From: Amanda Scholes on behalf of Planning.Responses
Sent: 27 June 2019 08:46
To: Planning Scanning
Subject: FW: EP/64/19/DOC
Attachments: Surface Water Drainage Proposals Checklist 130619.pdf

From: Laura Gibbons
Sent: 26 June 2019 16:05
To: 'Marmont Developments' [REDACTED]
Cc: Ben Daines [REDACTED] Anita Gardner
[REDACTED]
Subject: RE: EP/64/19/DOC

Thank you for confirming which surface water drainage scheme is being proposed. I have the following comments:

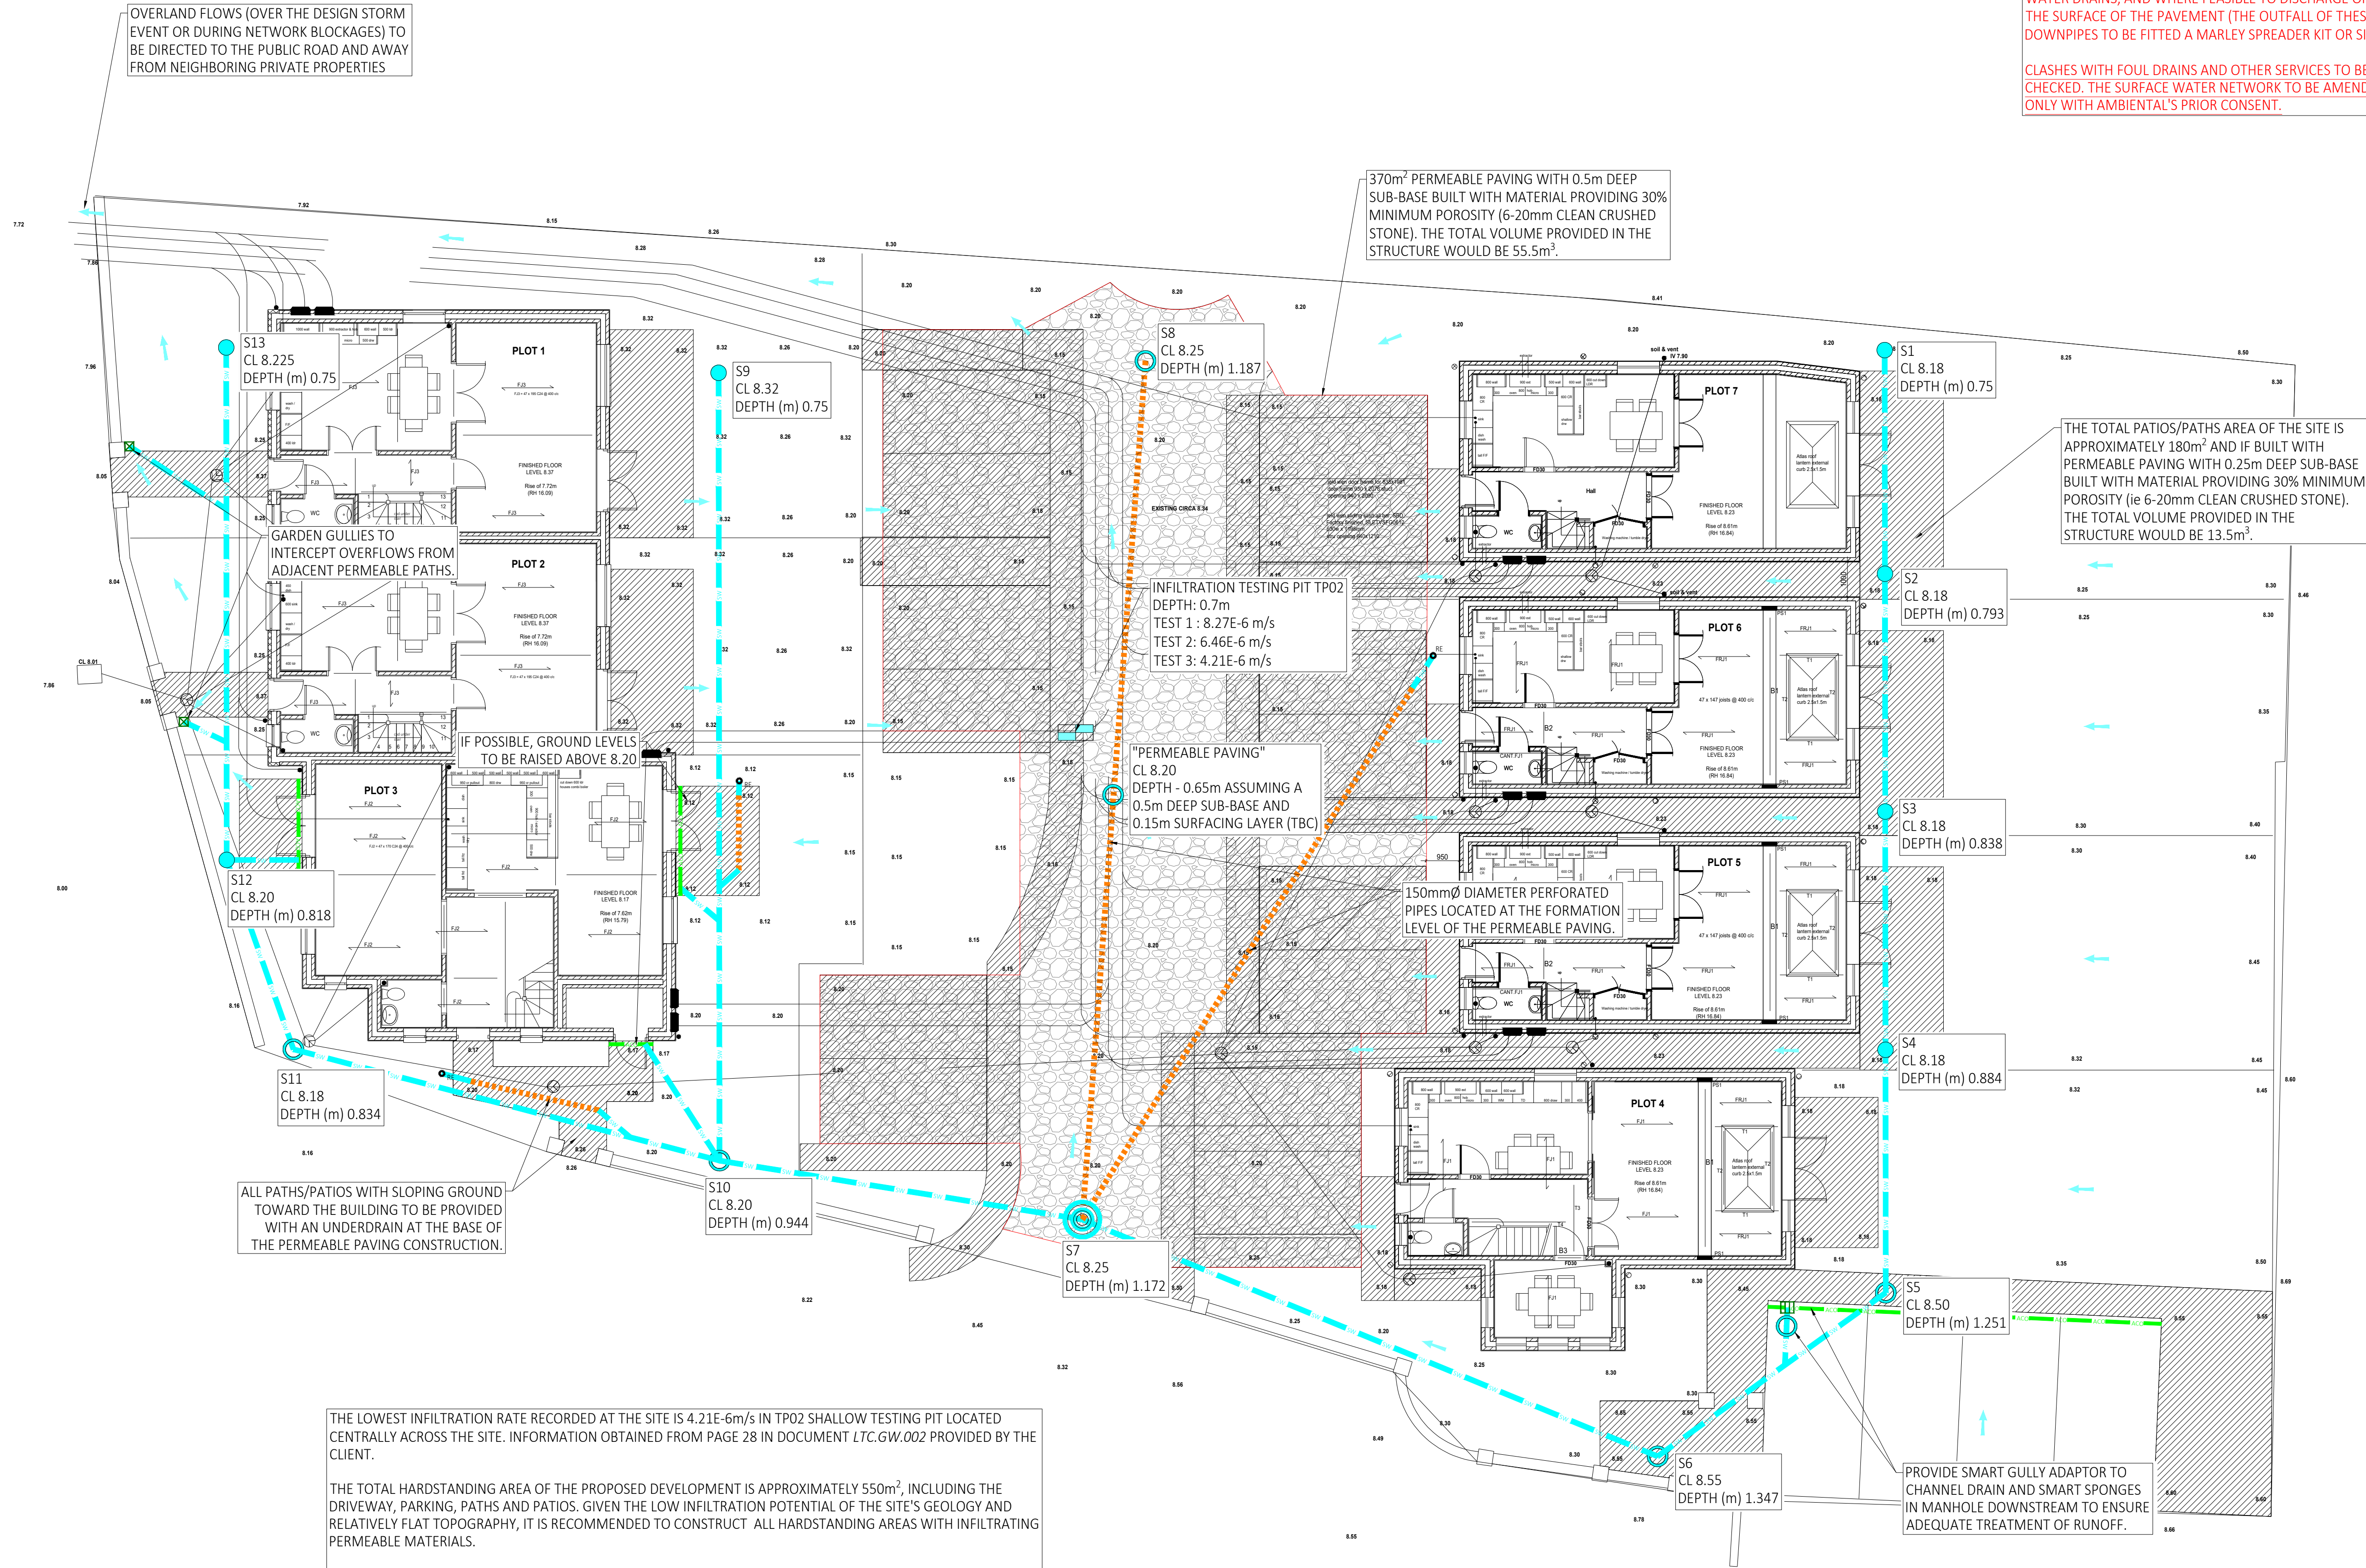
1. Layouts need to clearly identify the formation and finish level proposed for permeable paving.
2. Please can invert levels and not depths be expressed at each manhole.
3. The size and fall of all pipes needs to be clearly labelled on the plan.
4. Catchpit locations need to be clearly marked on the plan.
5. The factor of safety used in calculations needs to be revised to be compliant with requirements set out within CIRIA. Please refer to our checklist for further information on this.
6. Please can an impermeable area plan be provided.
7. Please can pipe numbers used in calculations be provided on the layout to facilitate my review.
8. The invert level of the permeable paving modelled is incorrect. Please can a cap volume depth also be modelled.
